**Nevertire Solar Farm Modification 4 (SSD-8072-Mod-4)
Request for Additional Information**

I refer to the proposed Nevertire Solar Farm Modification 4 (SSD-8072-Mod4). The Department is requesting that you provide additional information addressing the items below:

Figure 10: Viewpoint Locations – Context

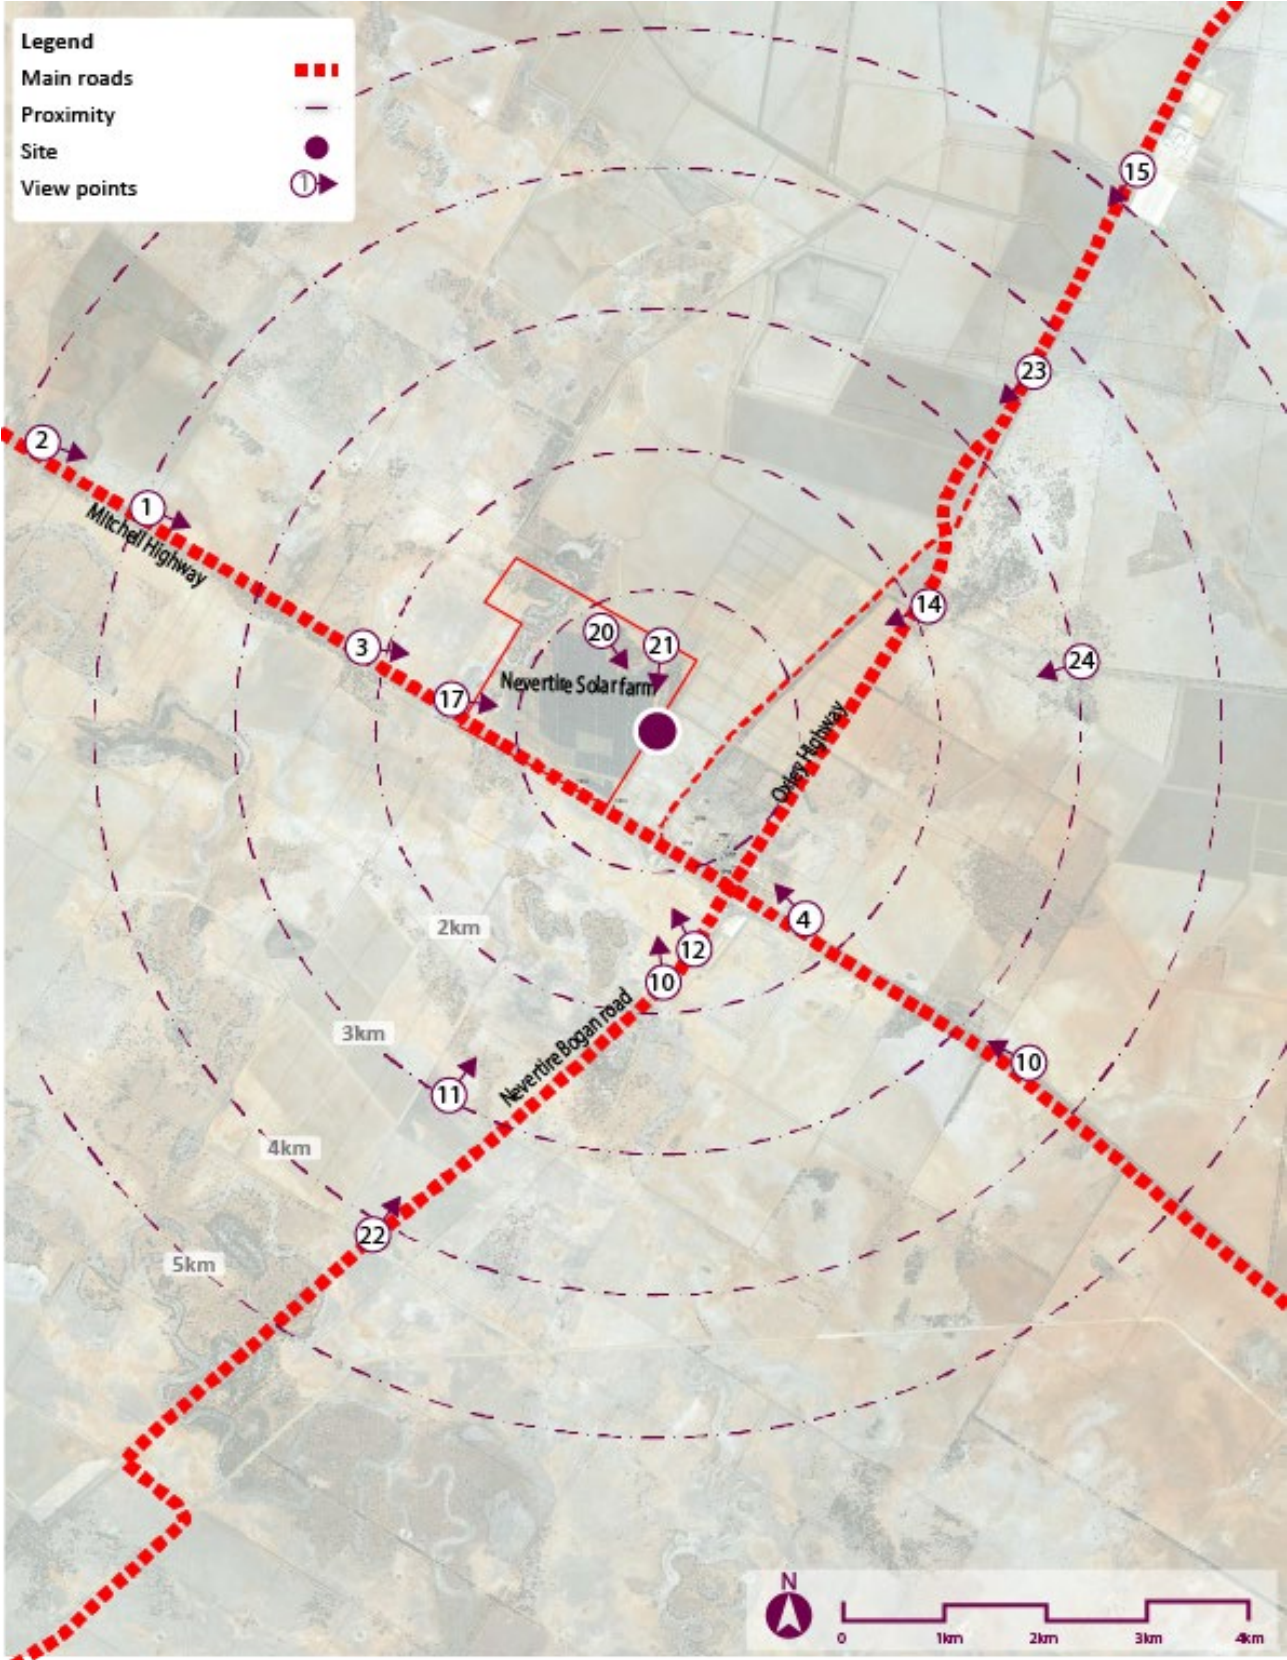
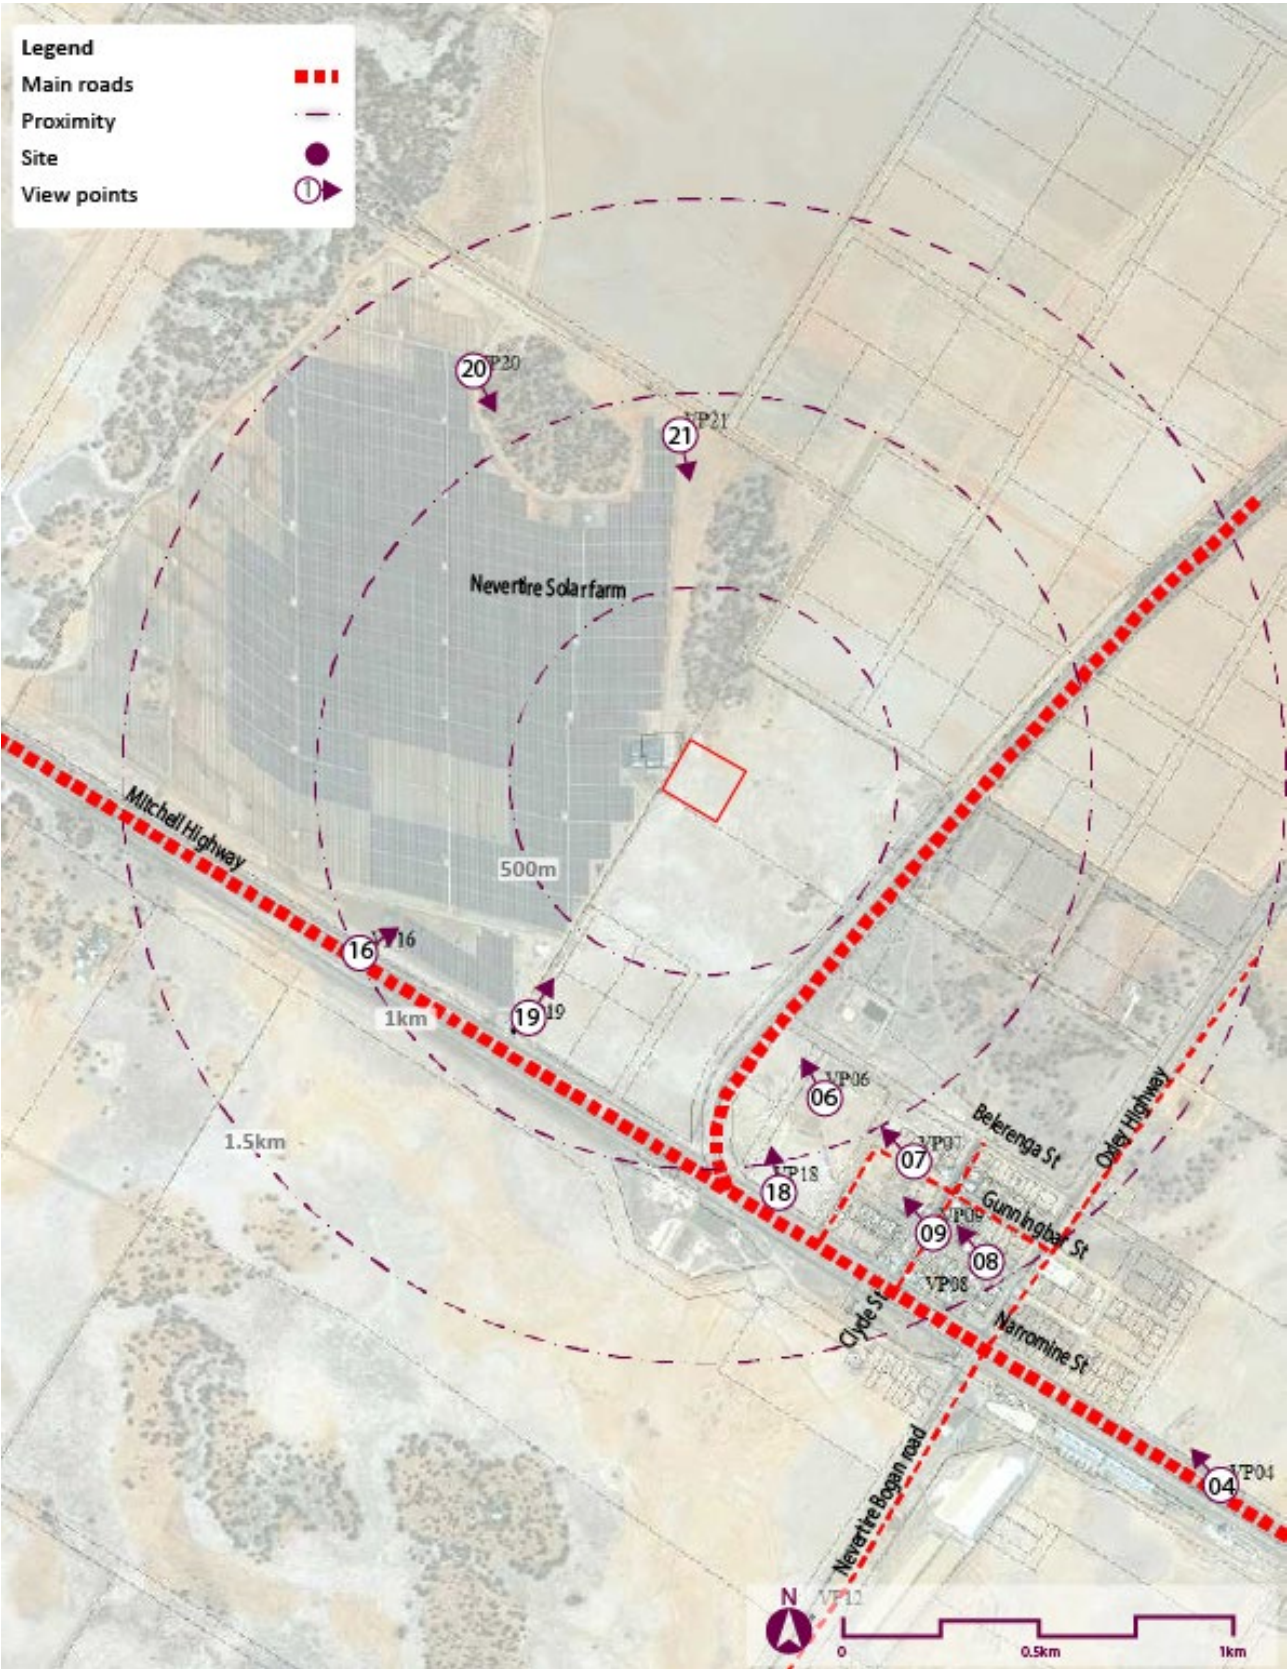
- update the Visual Impact Assessment to include analysis of visual impacts to residential receiver R21, confirm which of the selected viewpoints are representative of views from residential receivers and provide distances to these receivers;

PROJECT	NEVERTIRE SF BESS					
TITLE	NEVERTIRE BATTERY STORAGE OVERALL SITE LAYOUT					
DRAWING No.	PROJECT No.	AREA	TYPE	DISC	NUMBER	REV
520214	0000	DRG	EE	0003	C

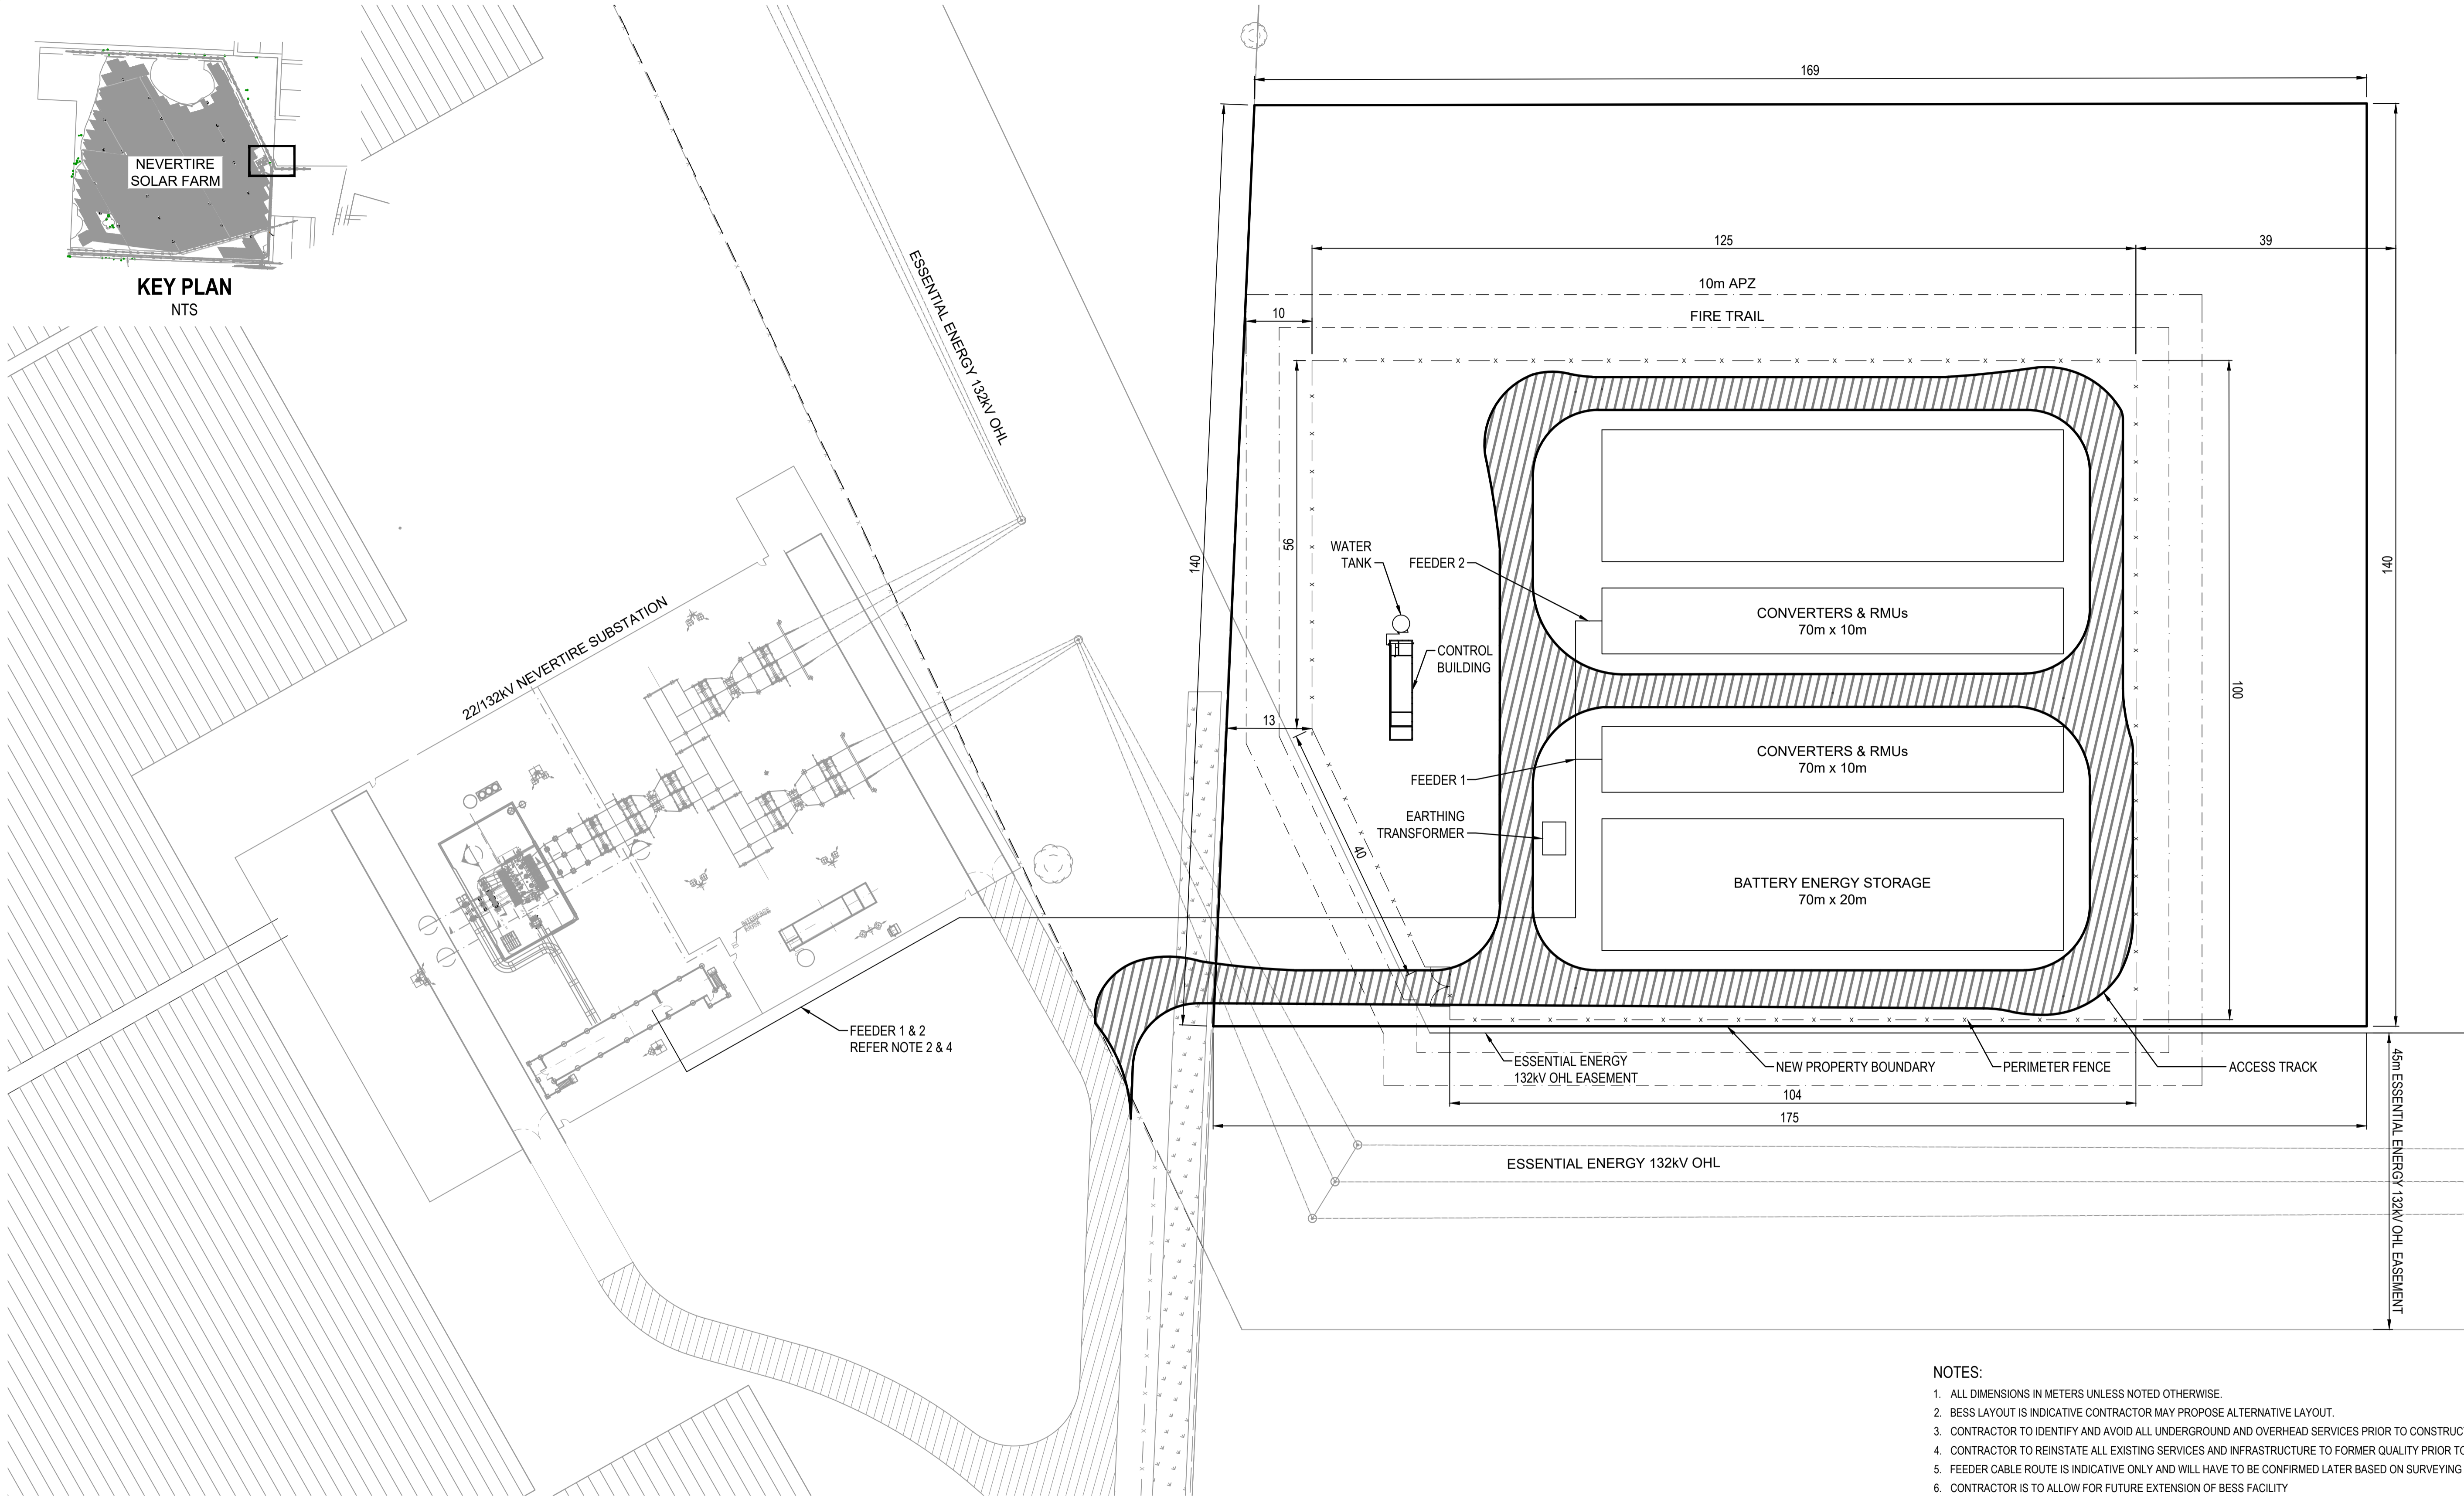
- verification that the Battery Energy Storage System (BESS) would be accommodated within the area designated for the BESS, accounting for separation between BESS sub-units to prevent fire propagation; and

- provide further information regarding flooding, noting areas of ephemeral water inundation occur on the western portion of the site which intersects with the proposed BESS footprint; and

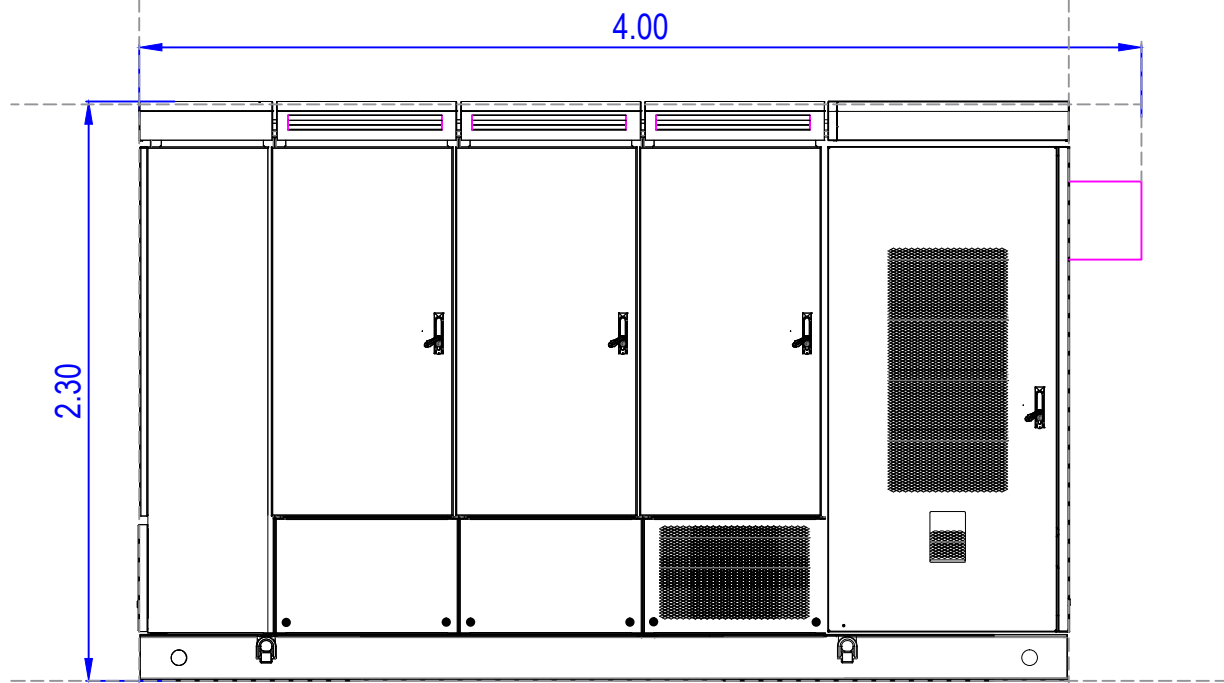
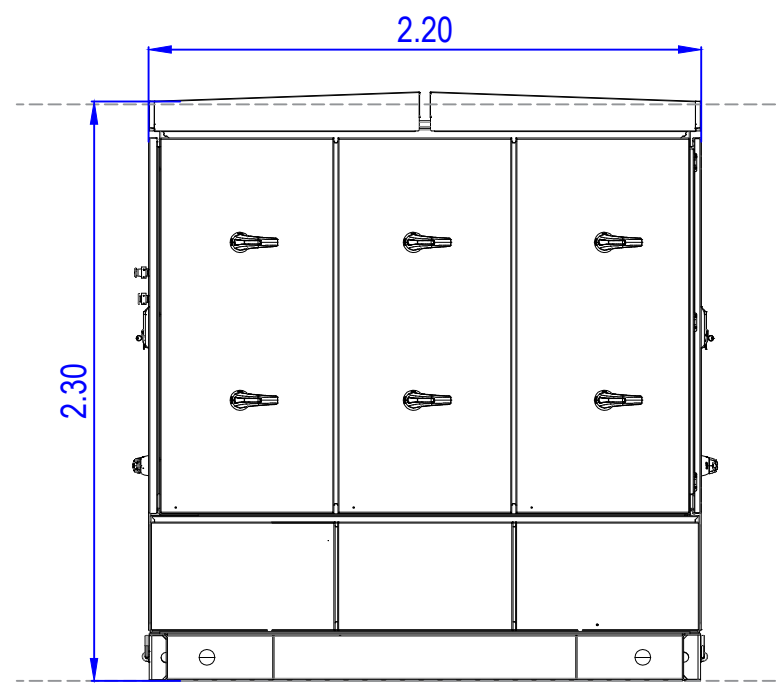
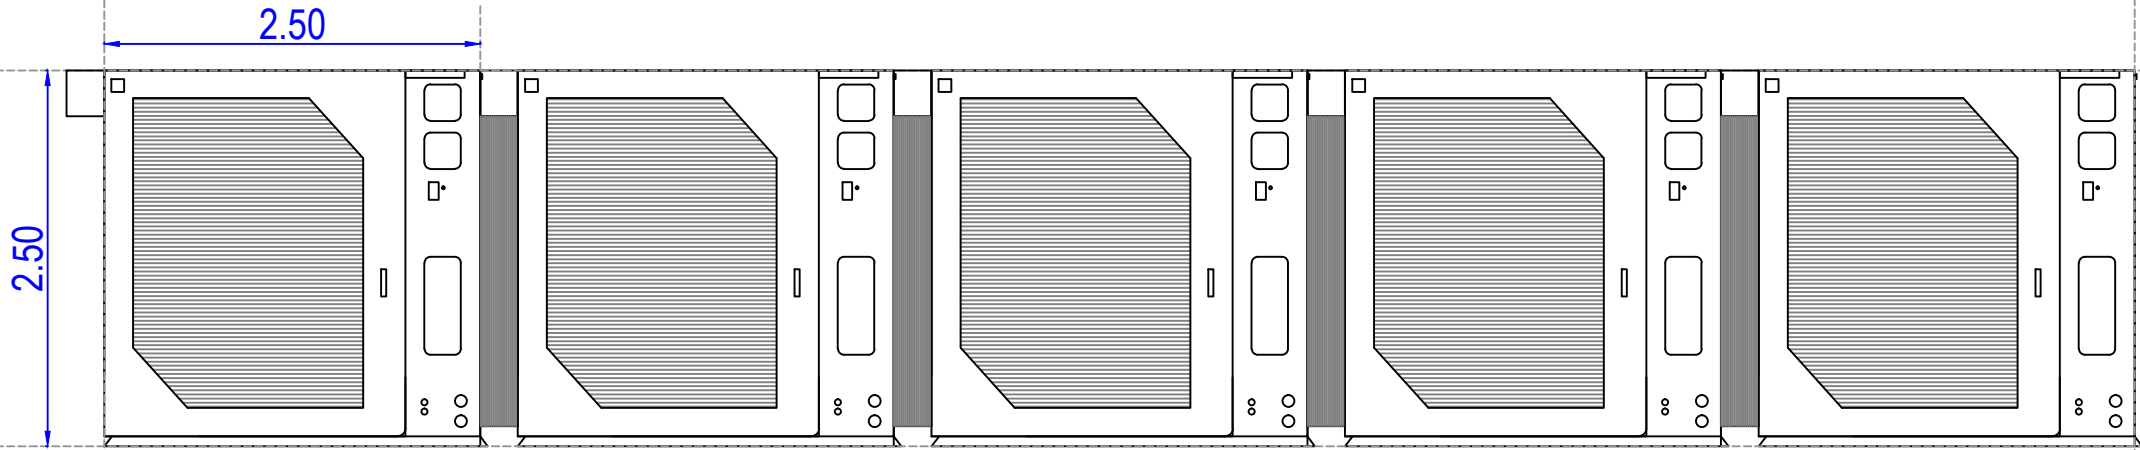
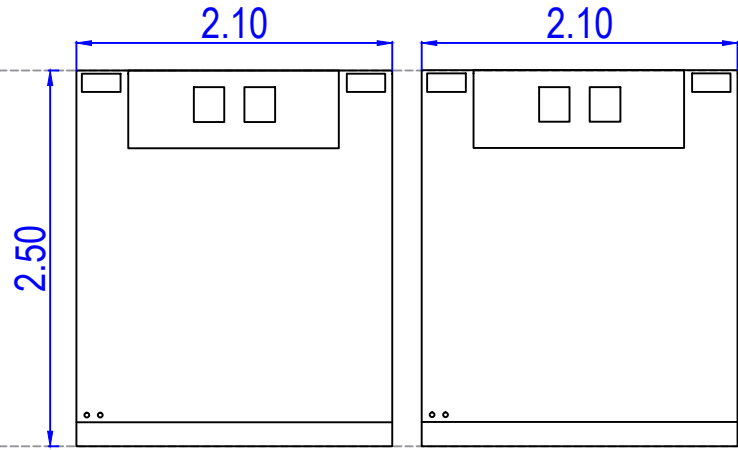
- confirm the height of the BESS containers noting the EIS refers to 2.6 m and 2.9 m.
